Planning Inspectorate Examination EN010137: Mona Offshore Wind

Cefn Meiriadog Community Council MNOW-ISP002

Deadline 5, 3 December 2024

Response of the Community Council to the Applicant's Change Request Application

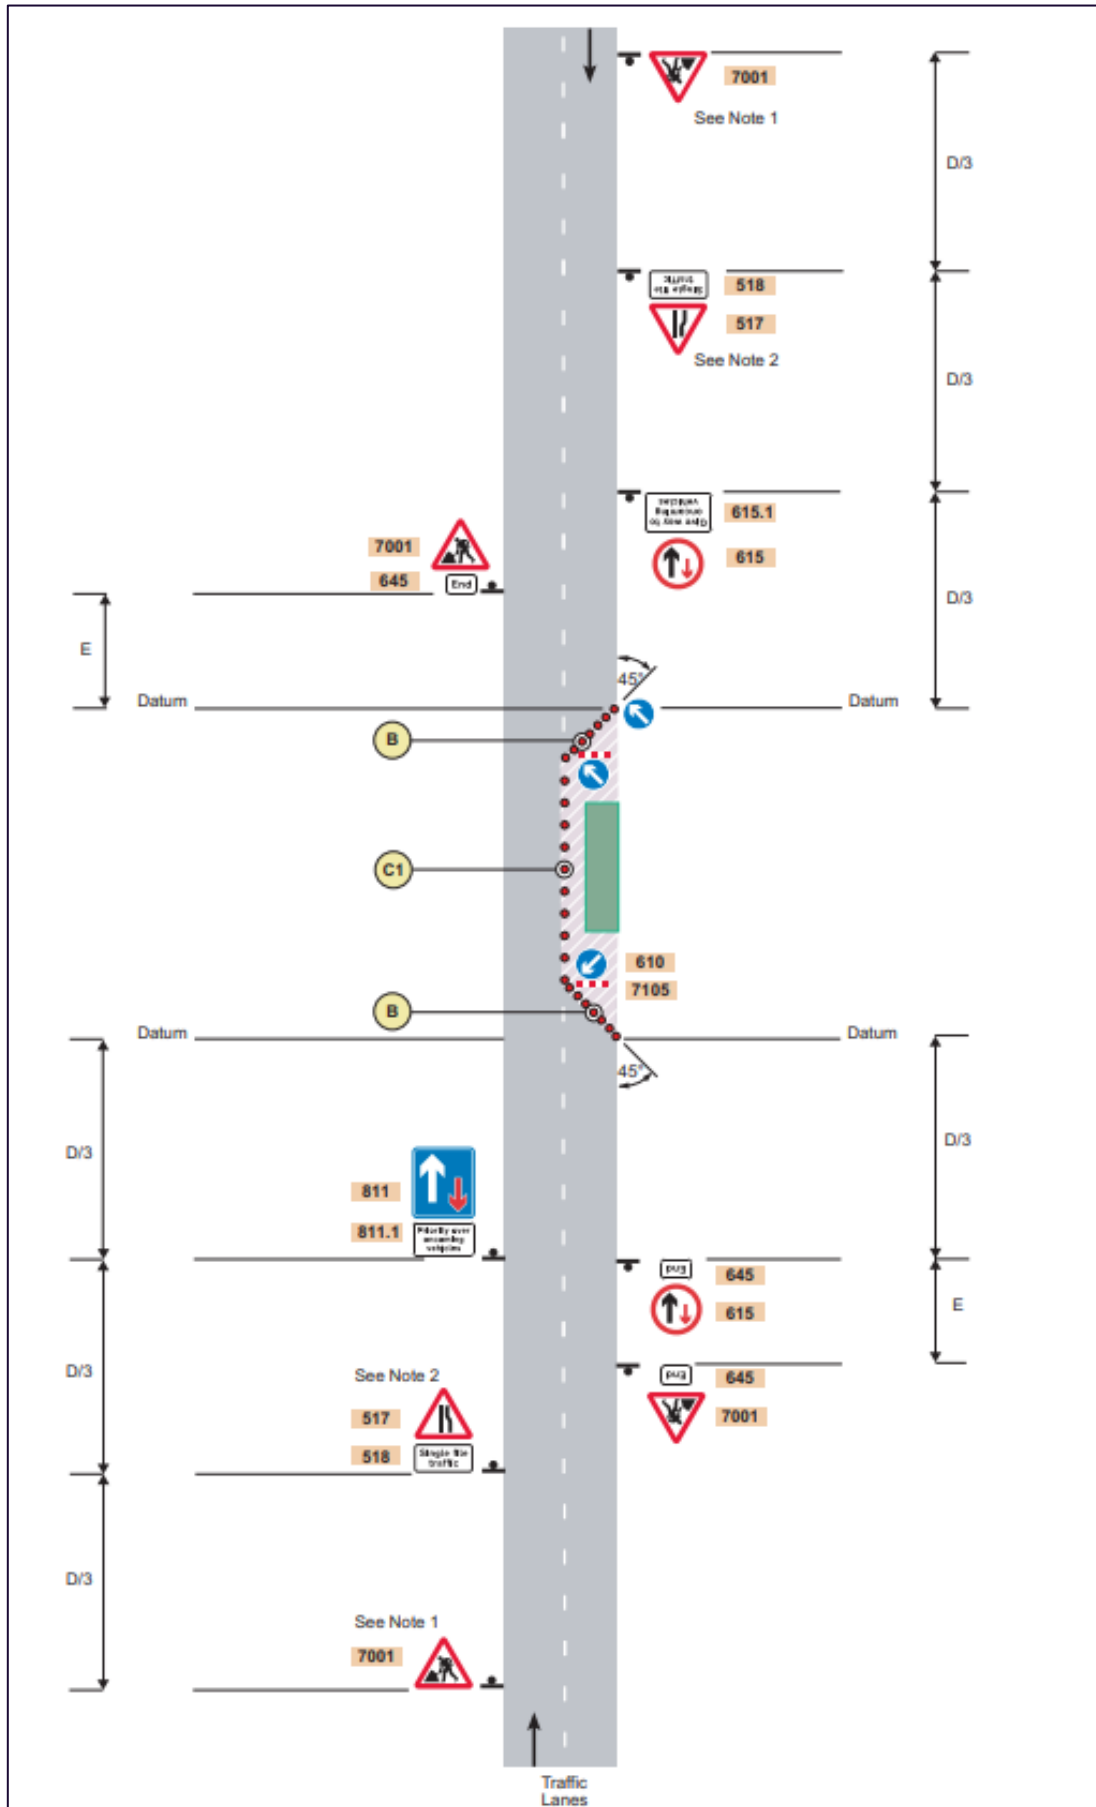
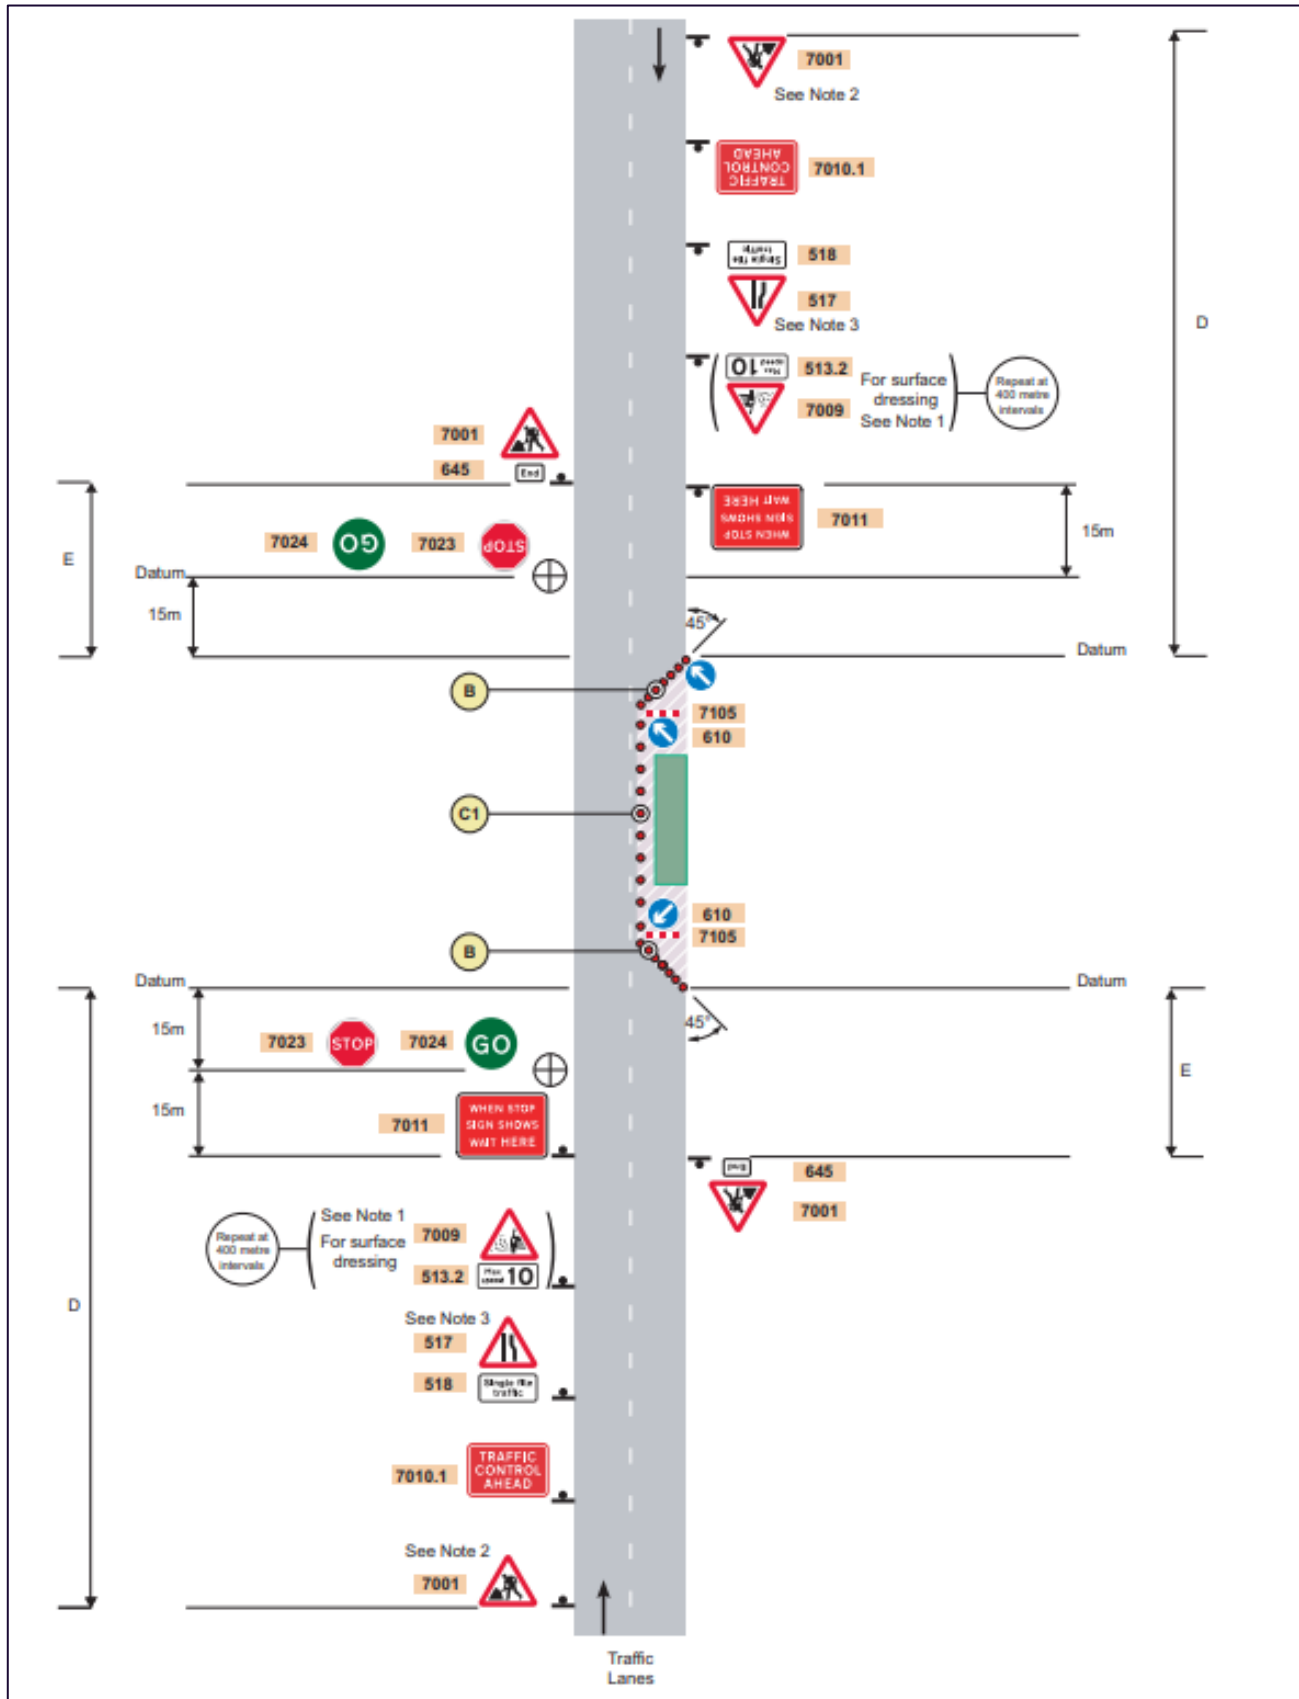
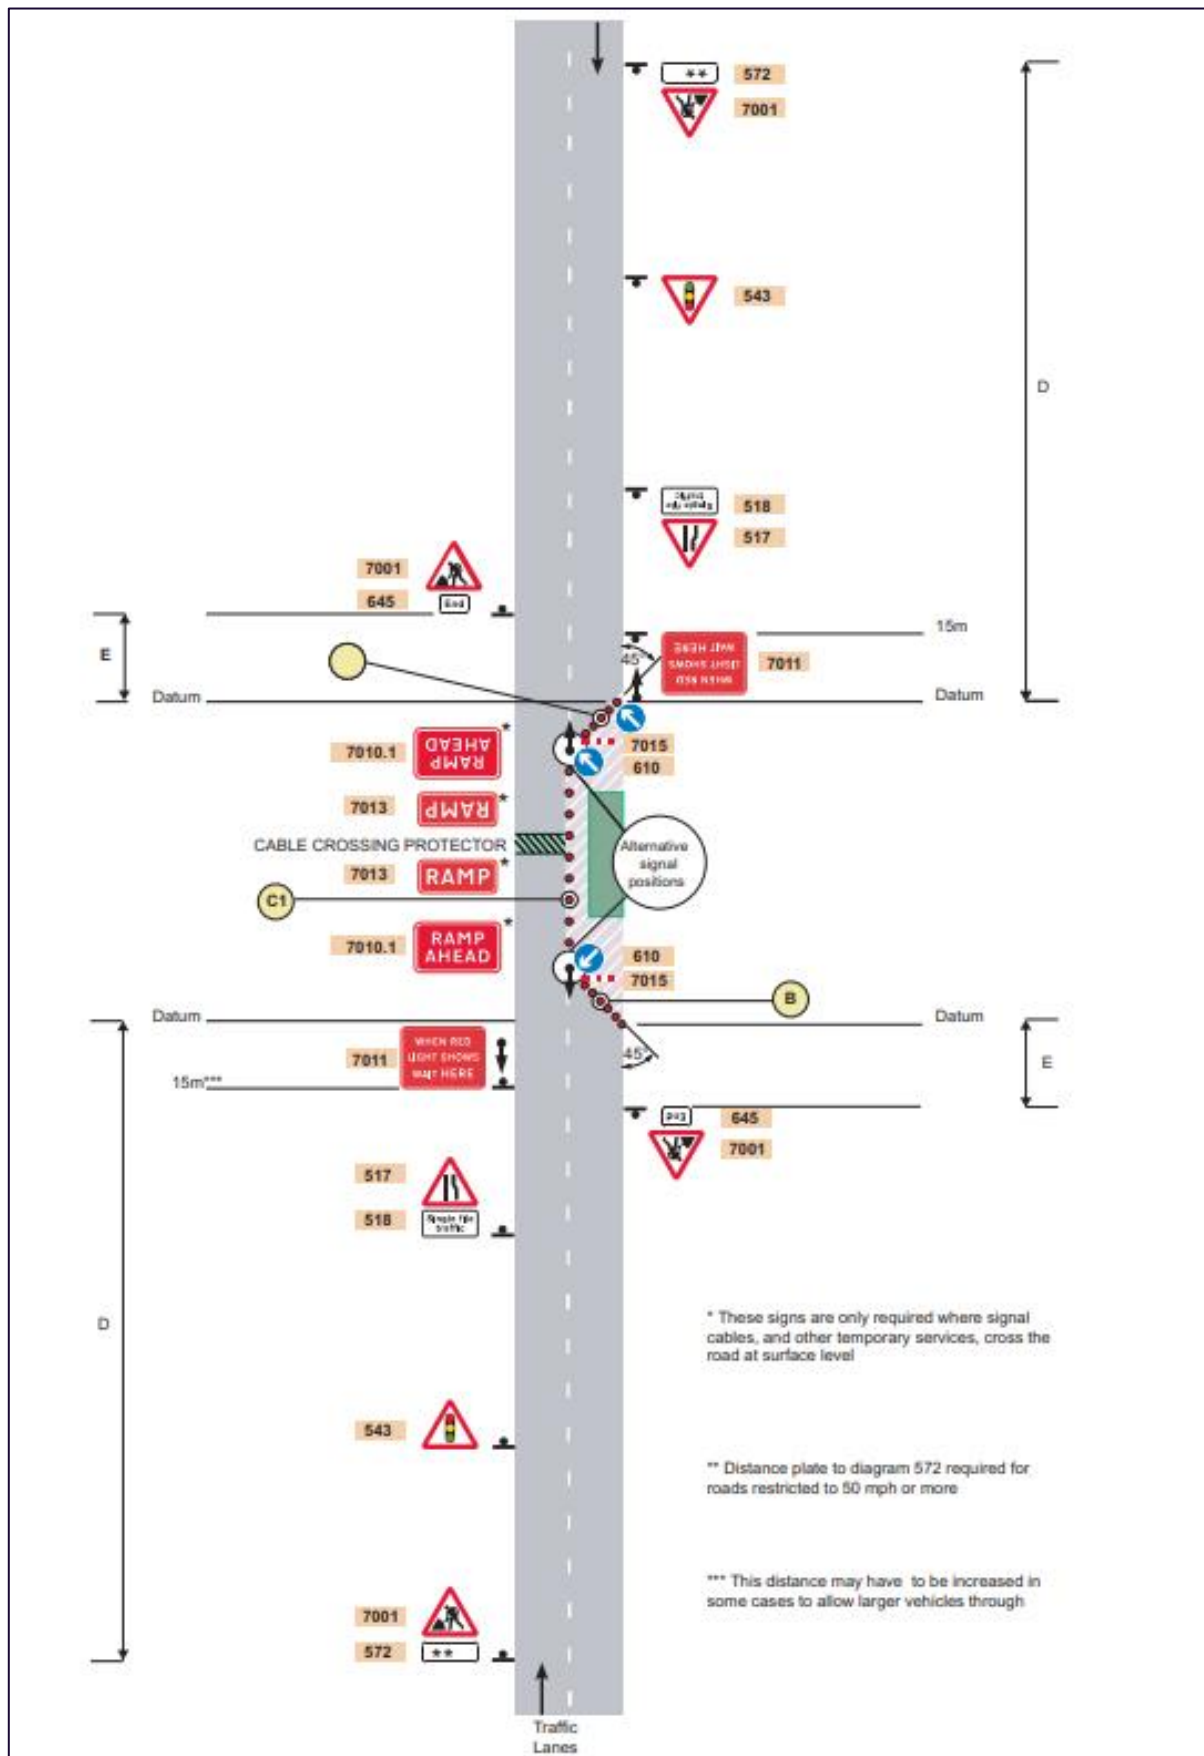
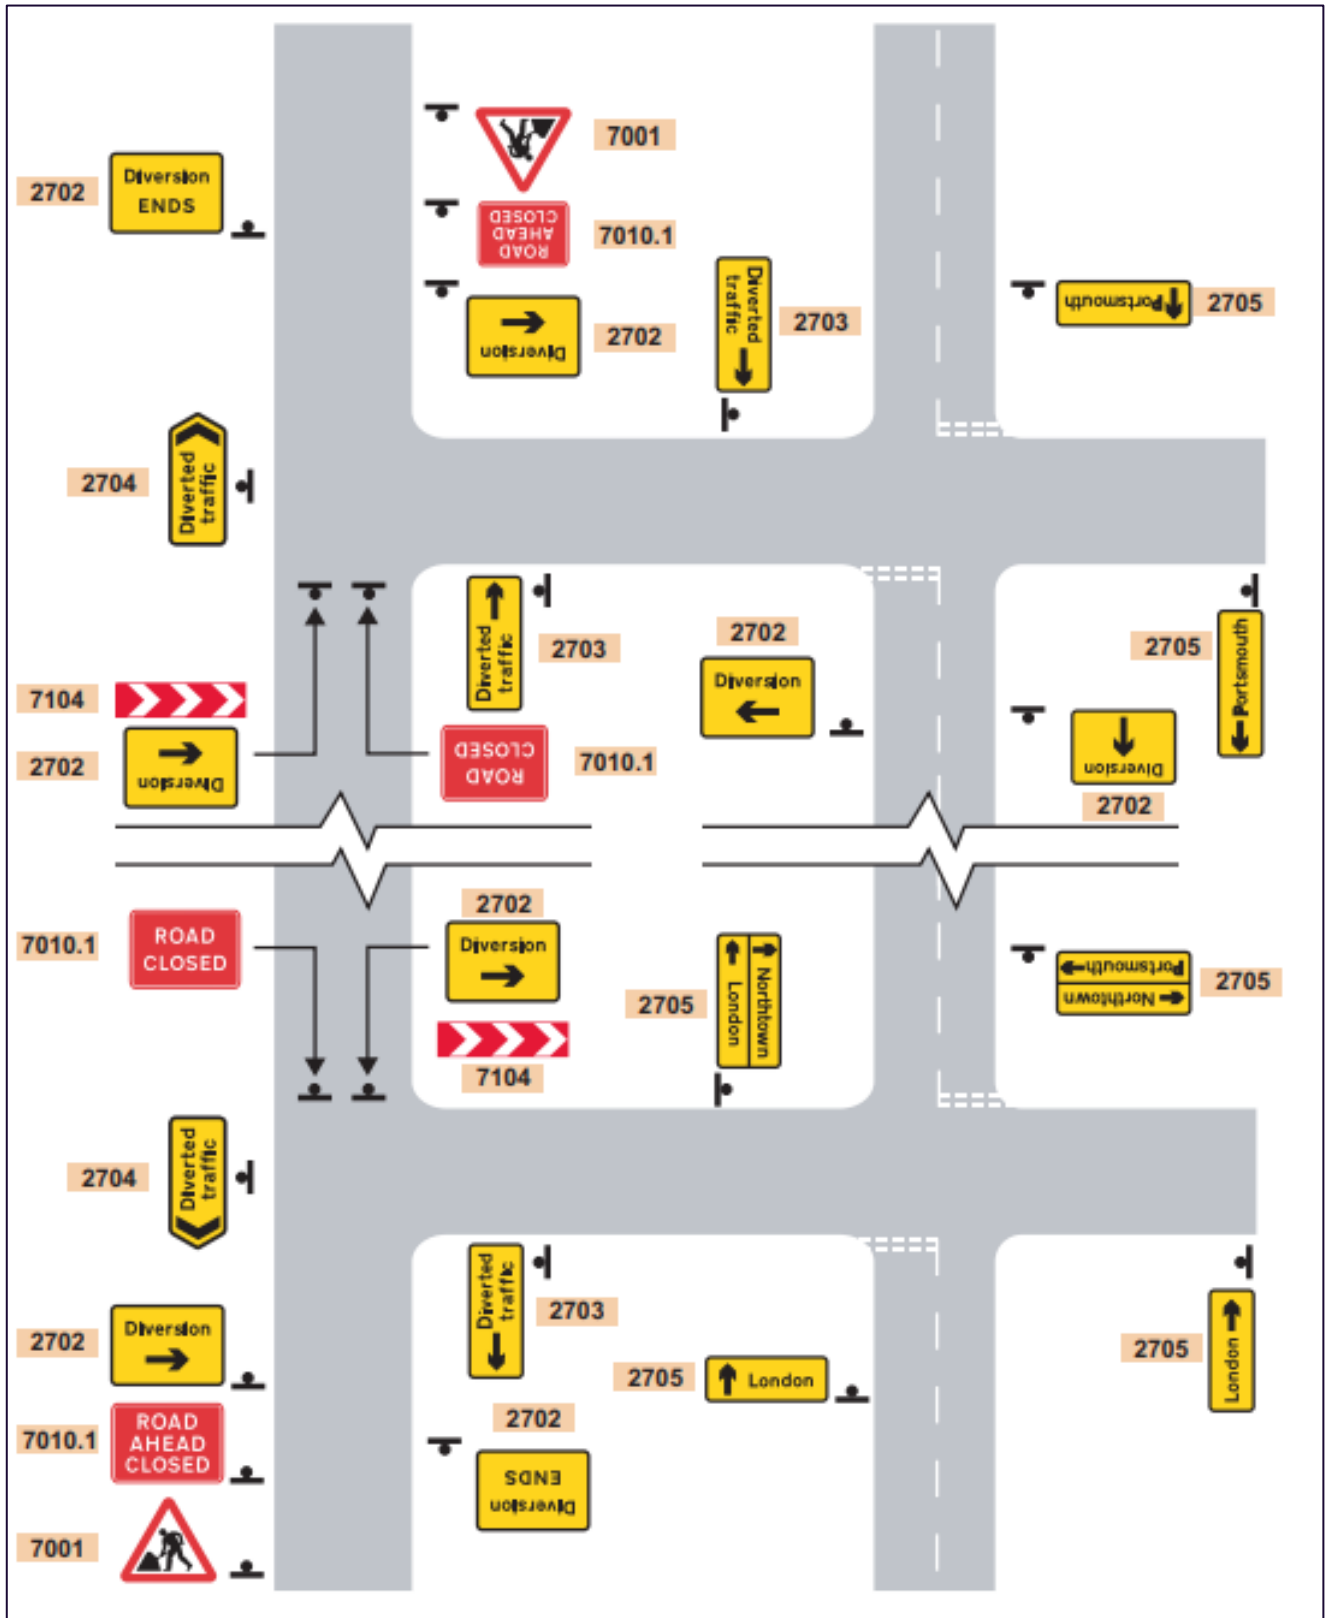
19. Purely in passing CMCC notes that in the OCTMP Figures 1.1 to 1.8, i.e. the depictions of road signage, all the road signs are monolingual. It is perfectly well understood that these are purely indicative examples and are, as the Applicant states, “generic in nature”. Nevertheless, similarly to the point made in paragraph 9 above, they display a regrettable lack of awareness of sensibilities within the community in which they are proposing to work for a long period and on which they will
